Our Ref: SB/SMP

Date: 30 April 2019

**TR010036 - A303 Sparkford to Ilchester Dualling Project - Examining Authority's Additional Written Questions**

***Question 3.8.1 Maintenance of Ponds***

Drawing Title
OUTLINE DRAINAGE WORKS PLANS
REGULATION 5(2)(p)
SHEET 1 OF 4

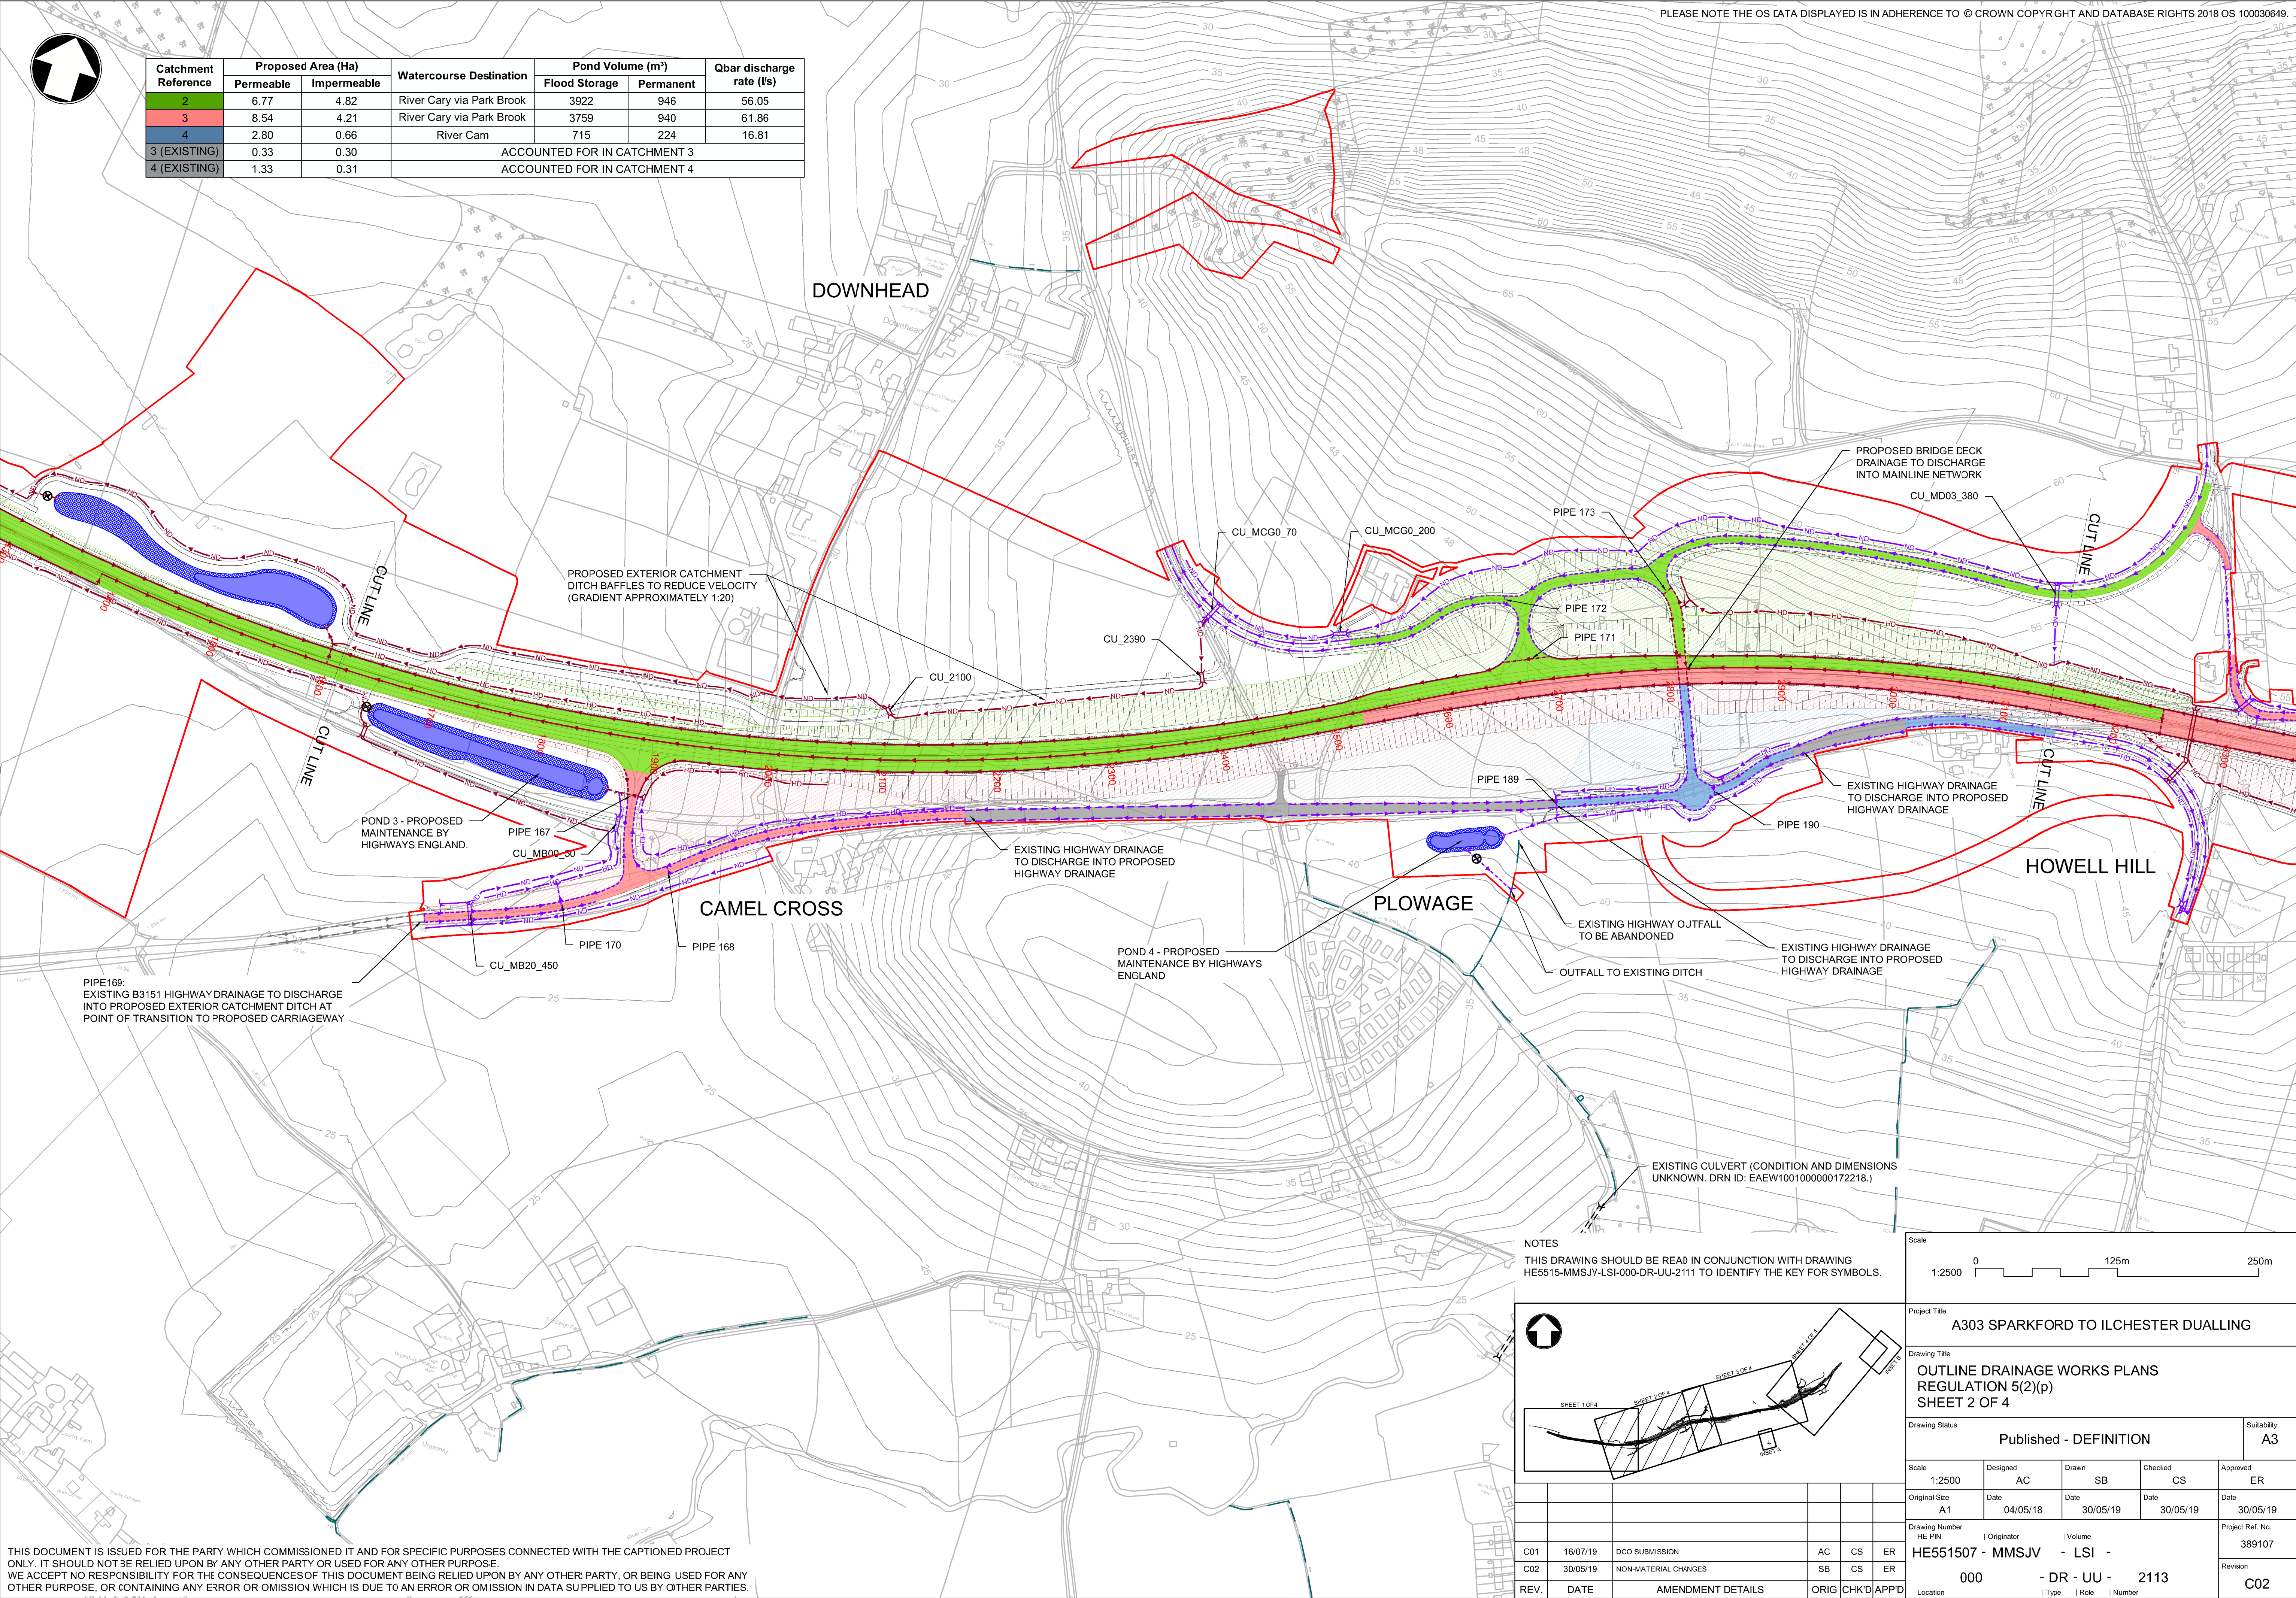
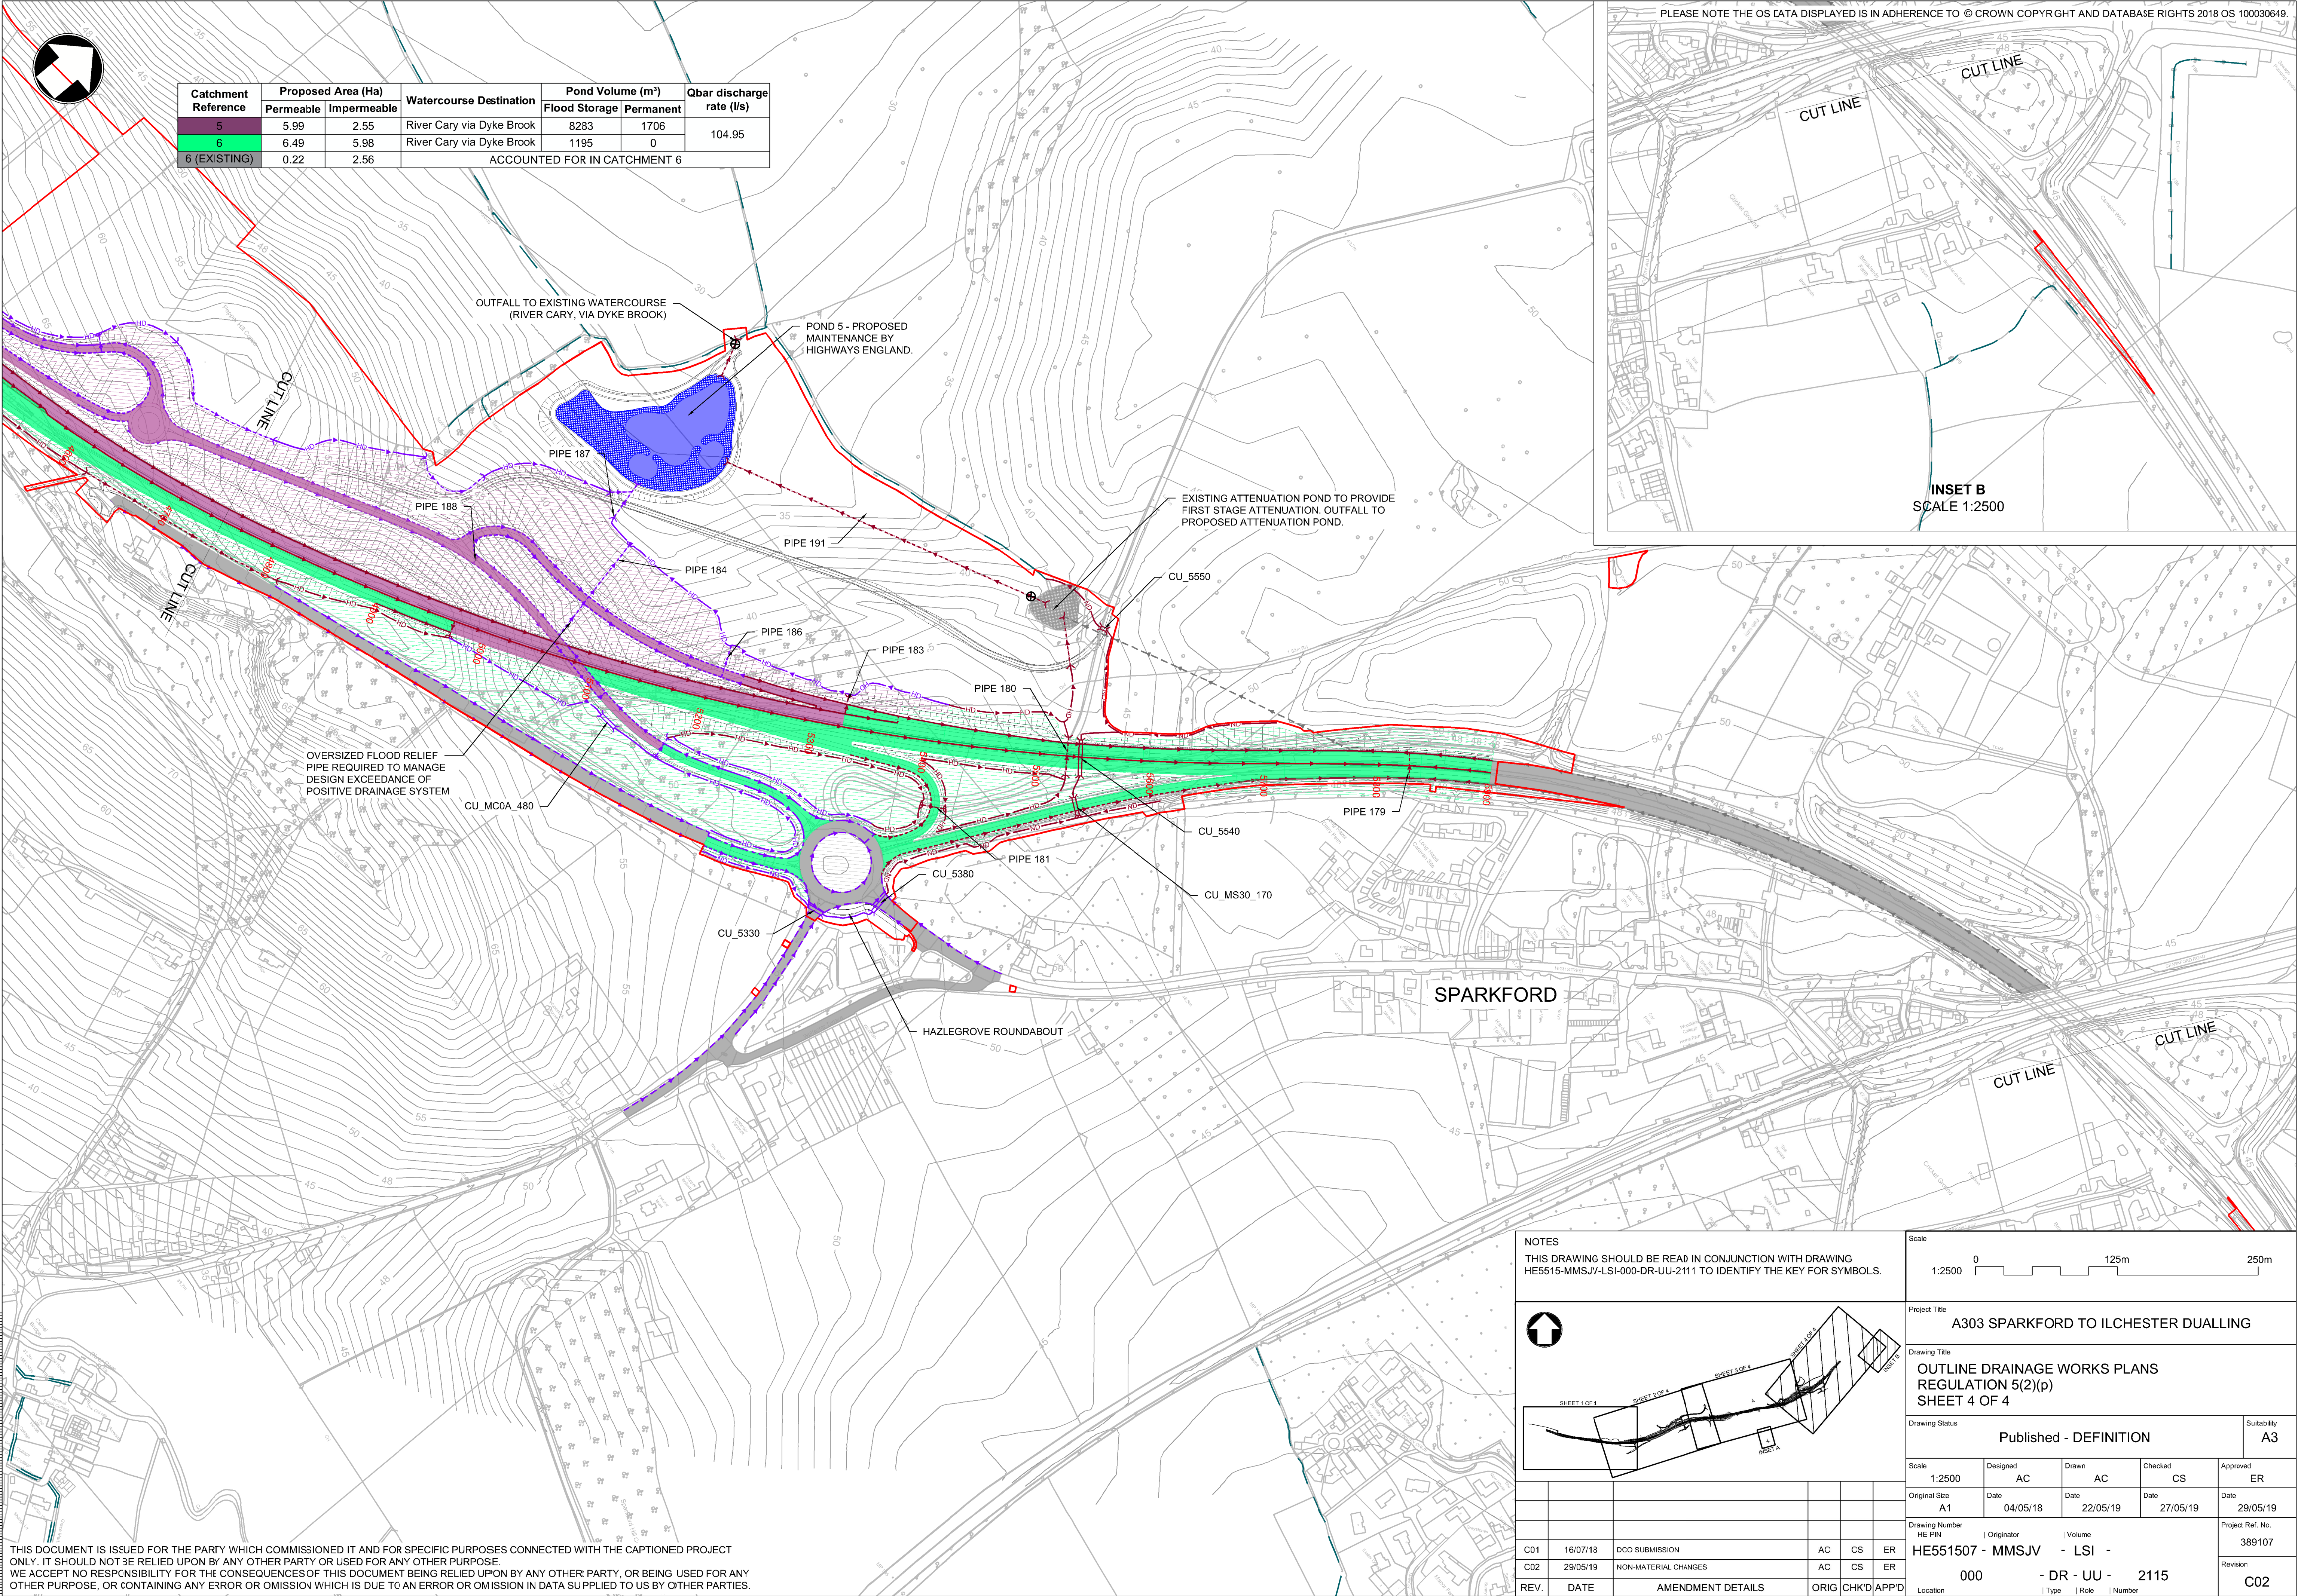
*In the Final SoCG between the Applicant and the Somerset Drainage Board Consortium [REP5-018] there is a dispute about the necessary width of any maintenance strips to allow for a full de-silt of the pond with the Consortium arguing for a greater than 4m strip.*

The Board is of the opinion that a minimum of 6m is required.

To operate safely the machine needs to be a minimum of 1.5m back from the edge of a pond or watercourse to ensure that there is no impact on the bank and a bank slip could potentially cause the machine to over-turn into the pond.

The machine width is around 2.5m wide and when the cab turns there is an overhang of 1m for the counterweight as can be seen below:

A safe working area of 1m should be left behind the counterweight. This adds up as:

**This equals 6m**

If the maintenance strip is only 4m wide a standard machine would not be able to safely operate and the task would be more complicated, more expensive and would be less likely to happen. This could mean a reduction in the volume of storage available in the pond which would increase flood risk.
